Subject: EP/148/19/PL - Scorton Lime Tree Close, East Preston

I have received the above application and looking through the drawings submitted I note there are the following anomalies requiring clarification:

Plot 4: Limetree Cottages.
Proposed Elevations, Floor
Plans, Roof Plan & Section

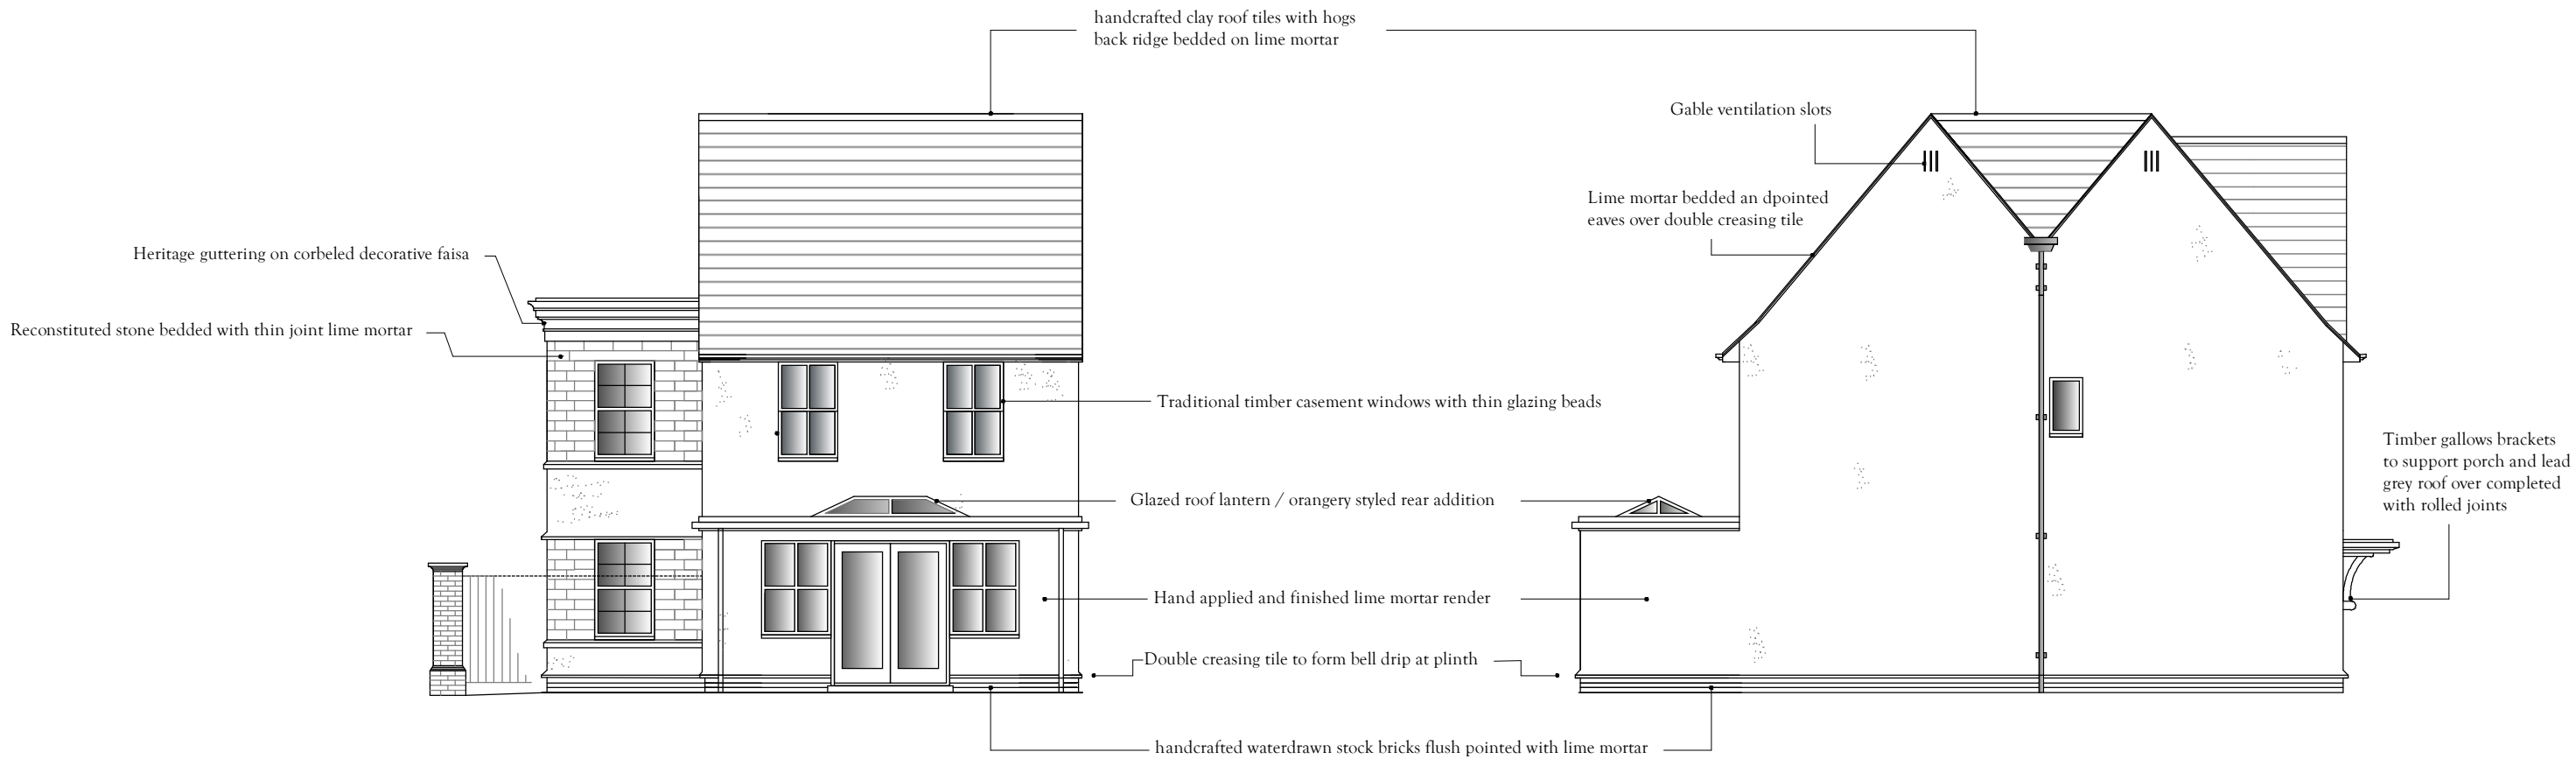
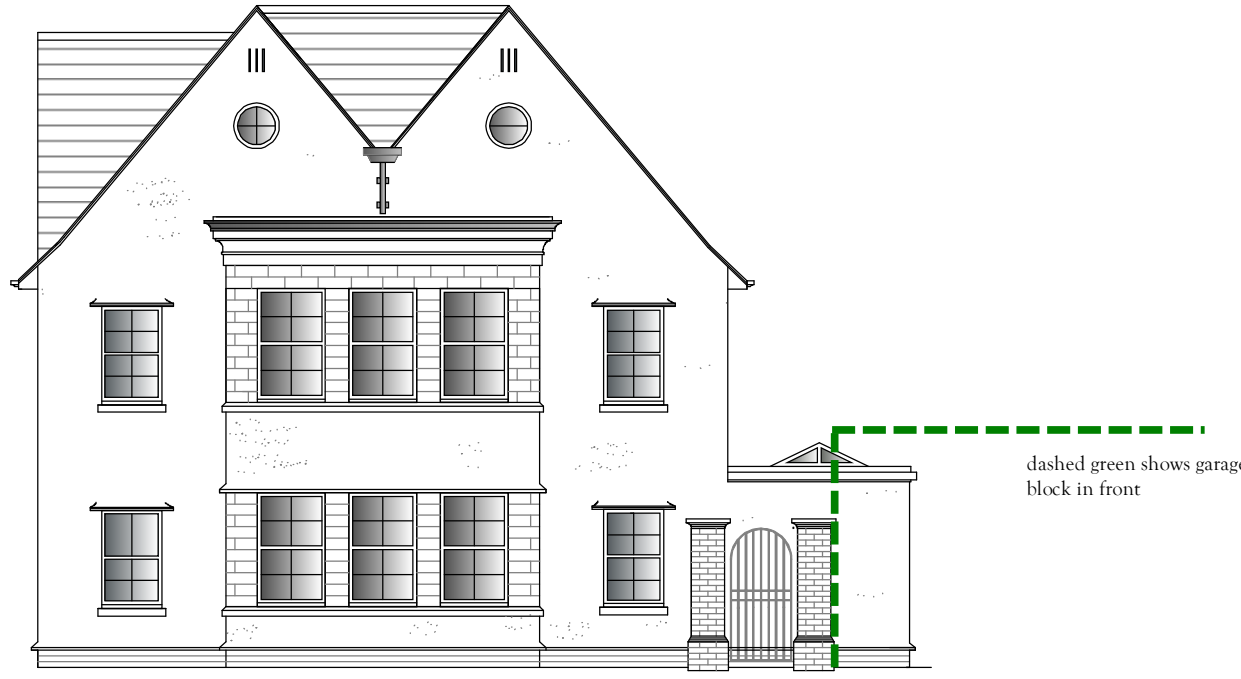
- On the layout plan The Cottage units fronting The Street indicate pitched roof dormers, although these do appear to have been approved on the elevations plan for EP/52/18PL they were not on the previously site approved layout plan.
- The notes on the elevations do not refer to the additional window in the south side elevation at first floor of plots 7, 5 and 6 or the additional roof lantern to the end plots.
- There are changes to the landscaping approved. In terms of species and at least one proposed tree has been altered to a hedge. The units fronting The Street now have additional patio areas indicated and there is a footpath added to the western site boundary.

Proposed Landscaping  
& Proposed Roof Plan

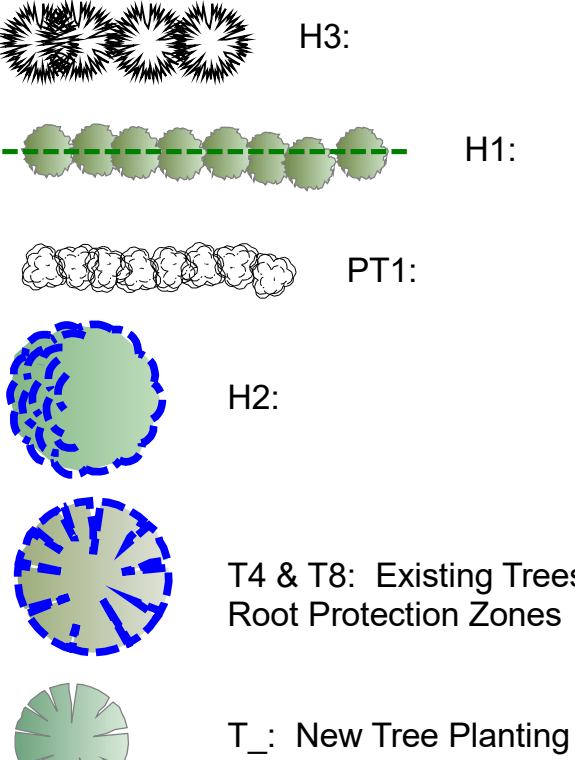
The description of the application is therefore incorrect since the proposal also relates to amendments to the site layout/landscaping. I would therefore also appreciate your agreement to the proposed amended description 'Application for variation of condition no.2 imposed on planning permission EP/52/18/PL relating to amendments to patio areas and landscaping including provision of footpath to western boundary of site and boundary treatment and amended internal layout & external appearance of plots 4, 5, 6 & 7 to create an additional bedroom to each unit'.
